## Moorebank Precinct West (MPW) Stage 2 (SSD 7709) Response to Submissions – issues raised by Transport for NSW

## ATTACHMENT A - RESPONSE TO ISSUES RAISED BY TRANSPORT FOR NSW

ALL TRANSVERSE LINEMARKING, PAVEMENT ARROWS AND CHEVRONS TO BE MARKED USING THERMOPLASTIC.

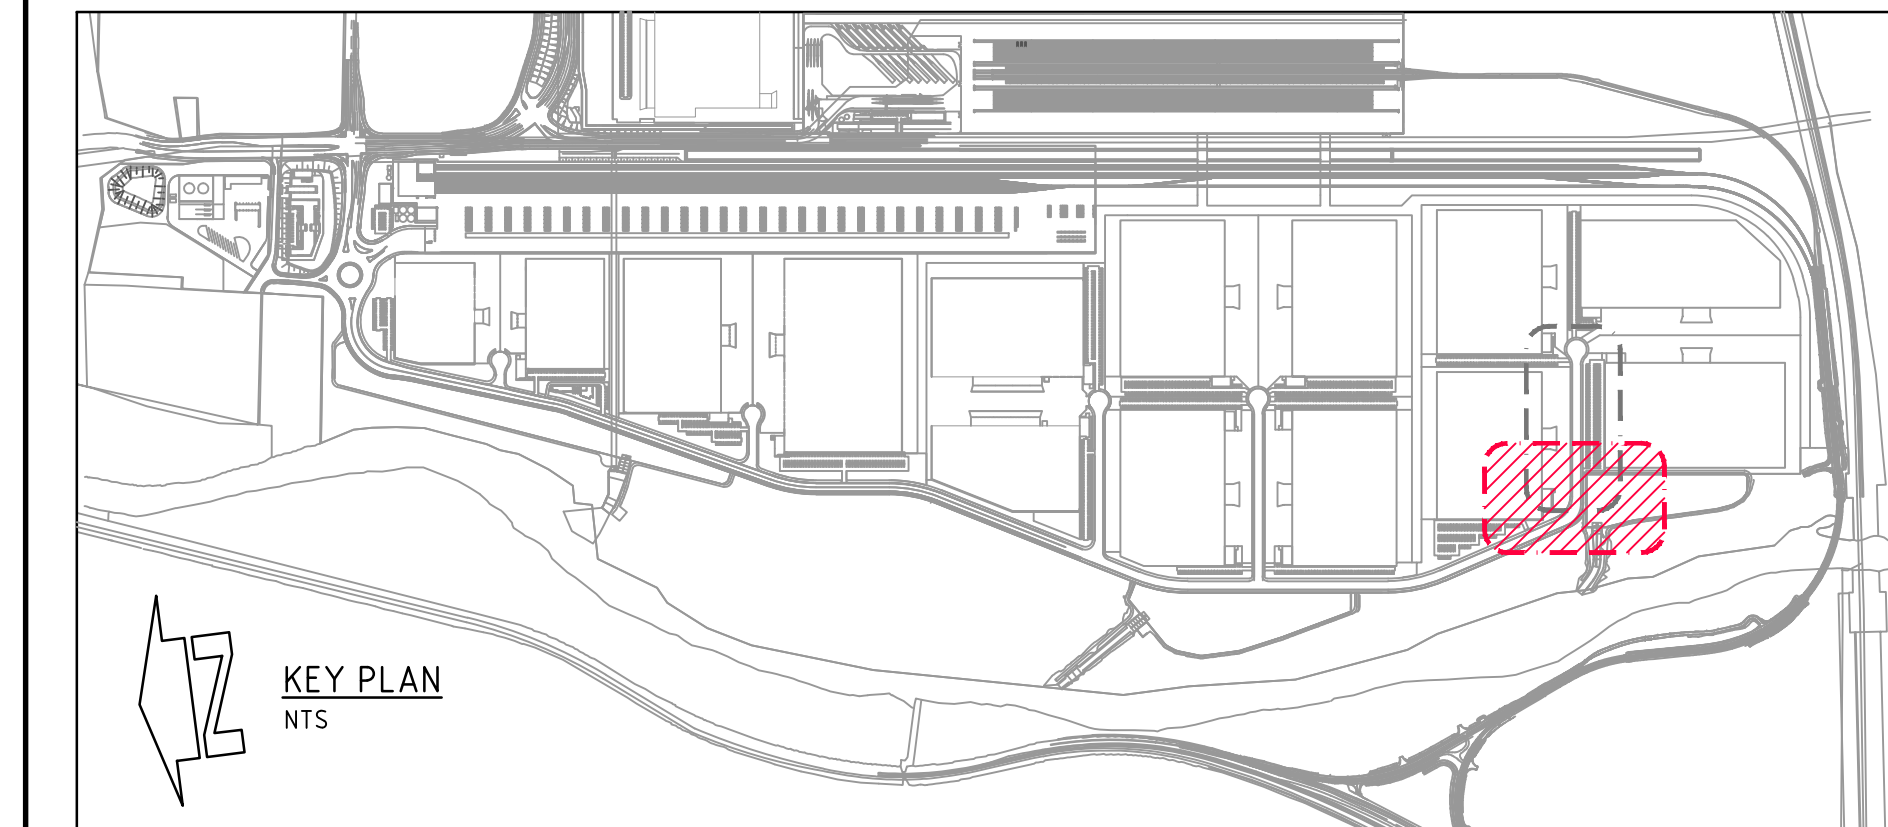
Aspect	Comment	Response	Reference
Adequacy of	Adequacy of Environmental Assessment against the SEARs  TfNSW is of the opinion that SEARs component 4i has not been adequately addressed (provide details of service vehicle movements and site access arrangements (including vehicle type and likely arrival and departure times of service vehicles)).  In their submission, TfNSW noted that 'Not considered as addressed in the sections nominated by the proponent i.e. Section 1.5, Section 1.6, Section 1.7 and Section 5.1'.	Service vehicle movements and site access arrangements	Section 1.5, 1.6,
Assessment against the		Service vehicles would access and egress the Proposal site via the Anzac Road / Moorebank Avenue intersection and travel within the Proposal site via the internal road network (refer to the revised architectural drawings at Appendix B for more information regarding the intersection layout and internal road network layout).	1.7 and 5.1 of the OTTIA (Appendix M of the EIS)

Both the Anzac Road / Moorebank Avenue intersection and internal road network has been designed to accommodate A-doubles. As service vehicles would be smaller than an A-double, adequate turning provisions will exist for service vehicles throughout the Proposal site. Site access arrangements that would apply to service vehicles are described in Section 5.4 of the OTTIA.	
		Service vehicle type and likely arrival and departure times	
		At the time of writing the EIS and this report, the type of service vehicles, and their likely arrival and departure times were unknown, as service contractors have not yet been engaged for the operation of the Proposal. As a result, the service vehicle types to be used are currently unknown. The likely arrival and departure times of service vehicles at the time of writing is therefore unknown, and would be dependent on the service contractors, once identified.
